Re: Engineering Services  
2665 Ash Ave.  
Dunn, NC

Tyndall Project No.: 1701-020196

As requested by the client, representatives of Tyndall Engineering & Design, PA (TE&D) were on-site to observe the existing residential structure which had been constructed without permits or inspections by the municipality. Visual observations were only made in readily accessible areas. Therefore, conditions may be present that were not readily visible, not in readily accessible areas, or not part of the representative sample of components observed at the time of our site-visit. Any repairs implemented after our site-visit may reveal defects that were not apparent at the time when our visual observations were conducted. Should defects be discovered it is recommended that TE&D be contacted to evaluate the existing conditions etc. In areas where repairs are required, we recommend that all work be performed in accordance with applicable sections of the NC Residential Building Code or other applicable codes and that all work be performed by properly licensed contractors. TE&D should not be considered as liable for any defects or deficiencies which could not be reasonably discovered during the limite

THIRD FLOOR PLAN
 1/8" = 1'-0"
 CEILING HT. = 8'-10"

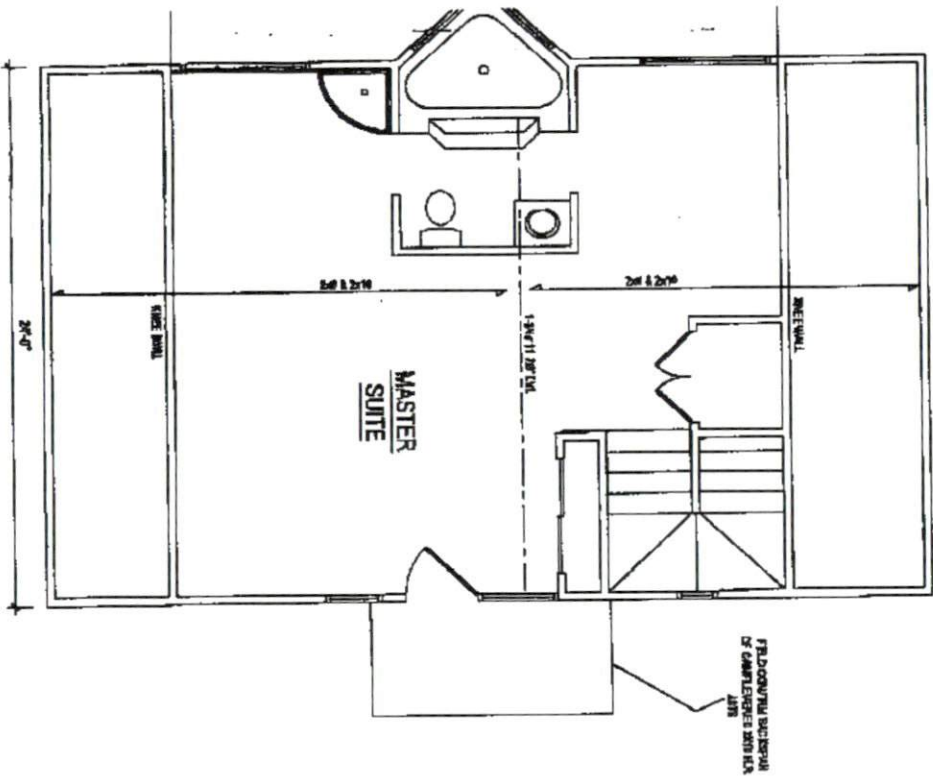
- 8) 4ft. Cantilever (2x10 floor joists) @ 3<sup>rd</sup> floor balcony.
- 9) Can't confirm roof support beam at covered porch roof located on right side of dwelling.

- 8) TE&D recommends that the backspan and supporting framing be field confirmed so that the joists may be properly analyzed.

FIRST FLOOR PLAN

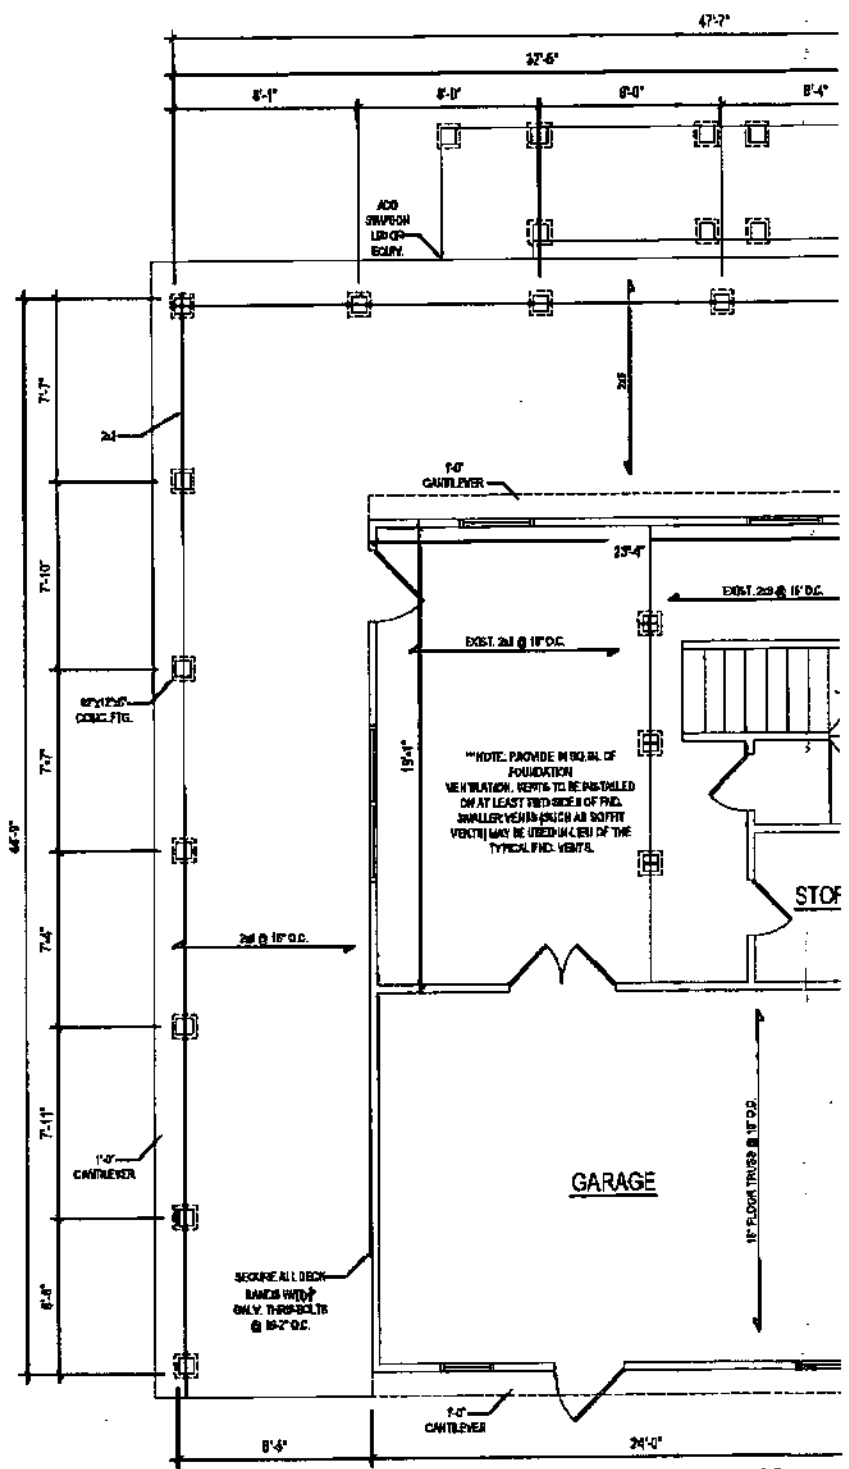
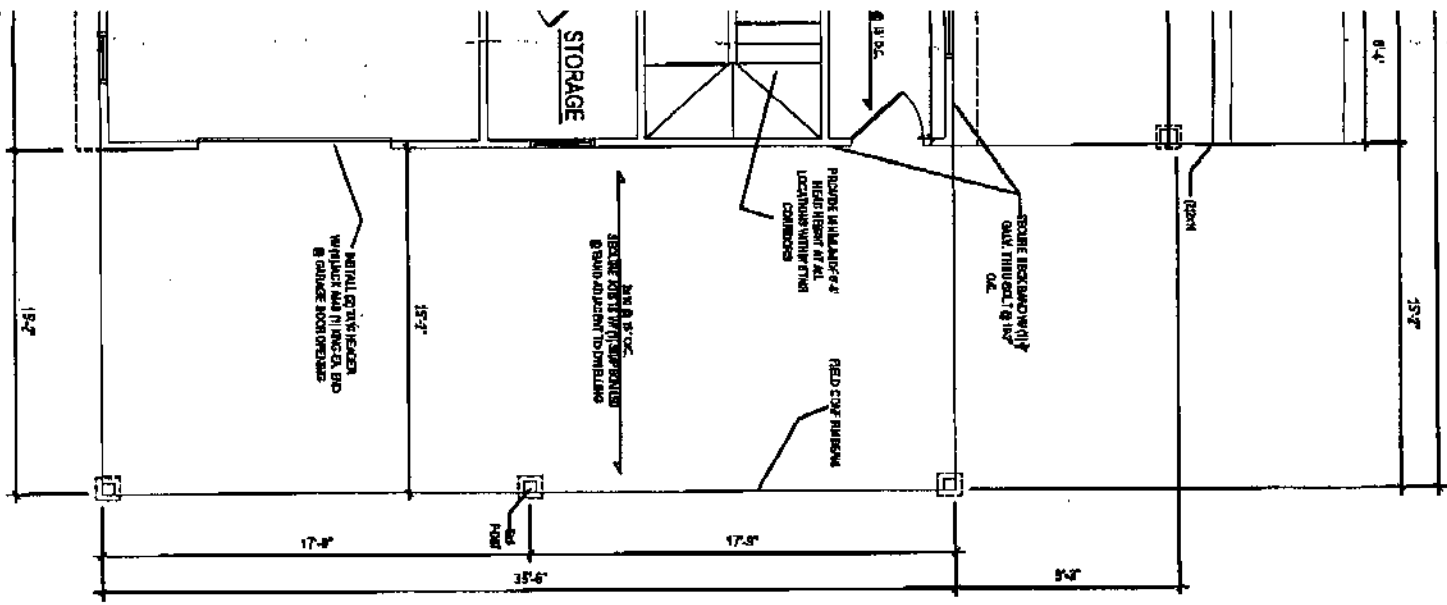
- 1) Floor joists associated with the ground floor were noted as being approximately 8" above the existing crawlspace grade. The existing floor joists were noted as being untreated 2x8 SYP joists placed at 16" O.C.
- 2) Untreated wooden girder members placed in direct contact with masonry associated with the girder support.
- 3) No means of foundation ventilation provided for crawlspace.
- 4) Minimum head height requirements (6'-8") not met at steps leading from 1<sup>st</sup> floor To 2<sup>nd</sup> floor.
- 5) Minimum head height requirements not met at 2<sup>nd</sup> landing encountered during ascension to 2<sup>nd</sup> floor.
- 6) Header not installed at single car garage door opening.
- 7) 1<sup>st</sup> floor wall studs 2x4 @ 16" O.C. in-lieu of code 2x6 for 3-story residential structure.

- 1) The joists' proximity to the finished grade does not meet the intent of the NC Residential Building code. TE&D recommends that this condition be addressed with the implementation of one (1) of the following options:

- b) Remove the existing untreated floor joists and replace them with treated members.
- 2) Provide metal flashing between the bottom of the floor joists and the top of the masonry units so that no direct masonry/wood contact remains.

- 3) The foundation should be provided with a means of foundation ventilation. Non-typical vents (such as soffit vents) may be installed through the masonry foundation block. Based on our observations and analysis, approximately 64 sq. in. of ventilation is required. The recommended foundation vents should be installed on at least two (2) sides of the existing foundation.

- 4) This condition occurs at multiple points within the stair corridors. TE&D recommends rebuilding the staircases as necessary to provide minimum head height clearances (6'-8"). Note: Installing a spiral staircase may be an option that could be considered for this item.

- 5) Based on our observations and analysis, TE&D recommends that a (2) 2x10 (spf) header be installed at the location in question. Provide one (1) Jack stud and one (1) king stud at each end.
